V1_Drainage Report - Preliminary.pdf Markup Summary

Retreat at P

PRAIRIERIDGE FILING NO. 1  
PRELIMINARY PLAN  
PRELIMINARY DRAINAGE REPORT  
PRE-DEVELOPMENT CONDITIONS

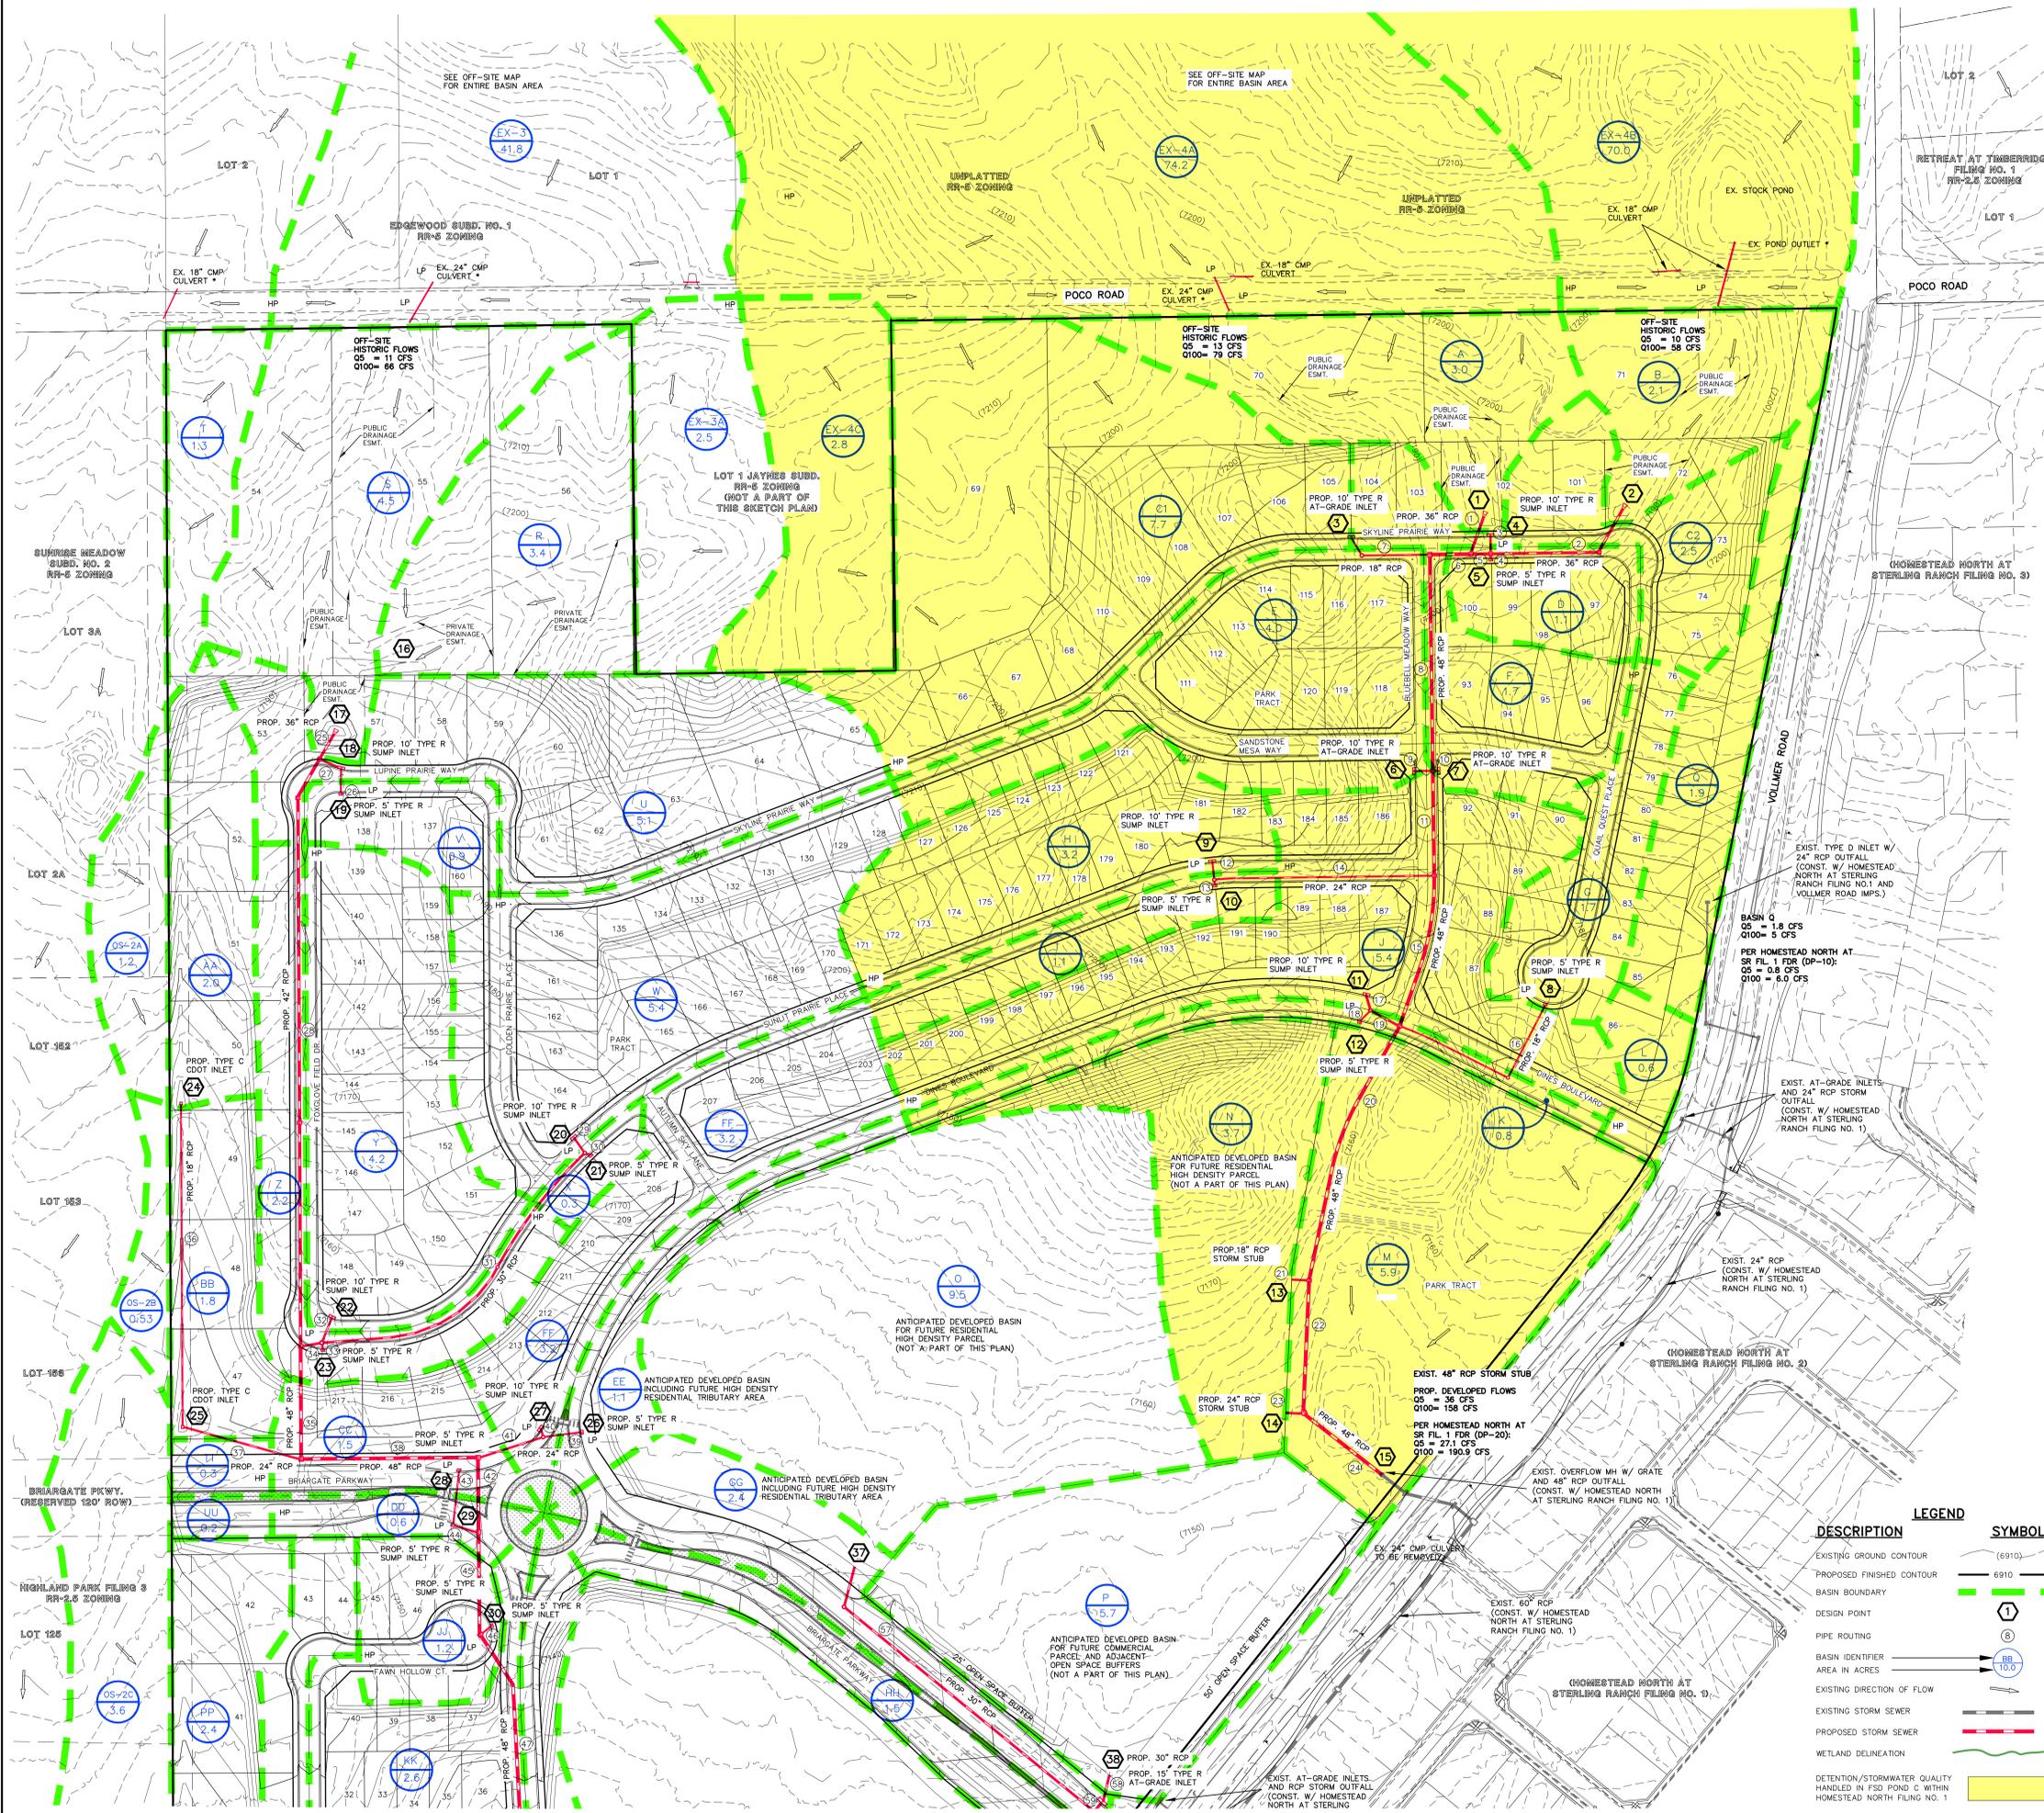
Update to correspond to basin areas and labels as shown on this map or clarify what/where these basin represent.

**PRAIRIERIDGE FILING NO. 1 PRELIMINARY PLAN PRELIMINARY DRAINAGE REPORT DEVELOPED CONDITIONS**

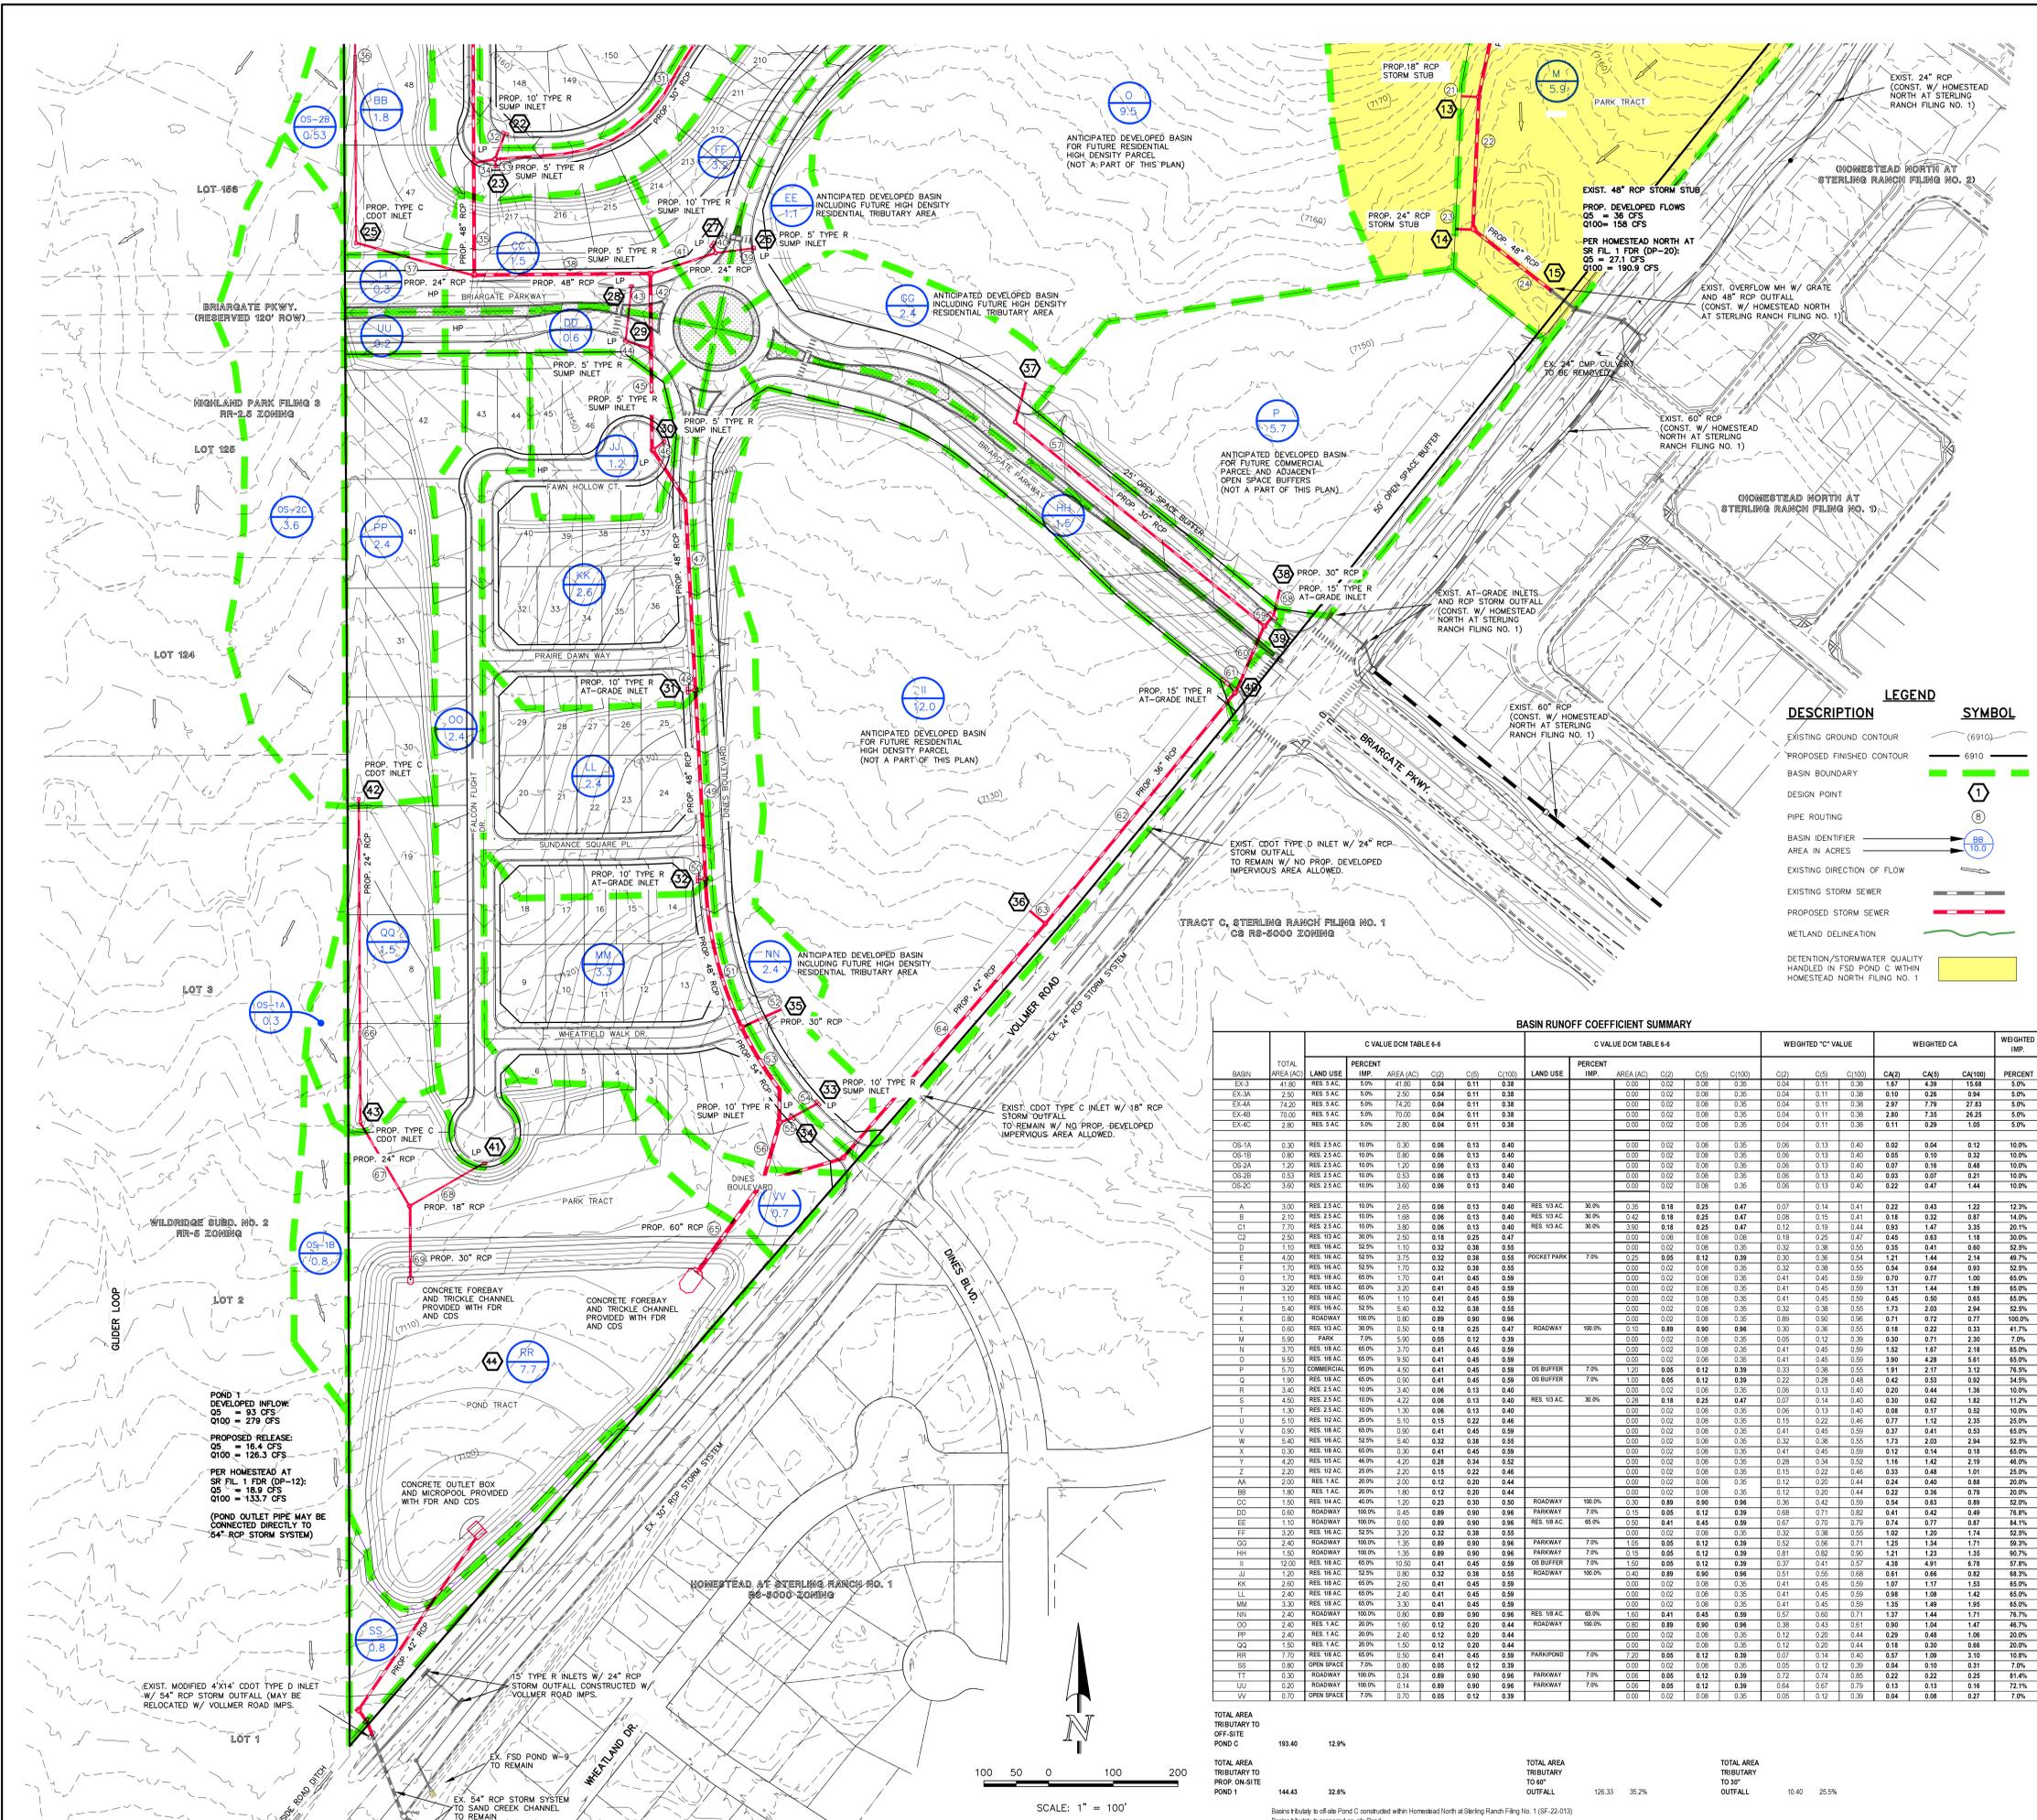
Note: At the FDR stage an analysis of these
existing culverts crossing under Poco Road will
need to be provided.
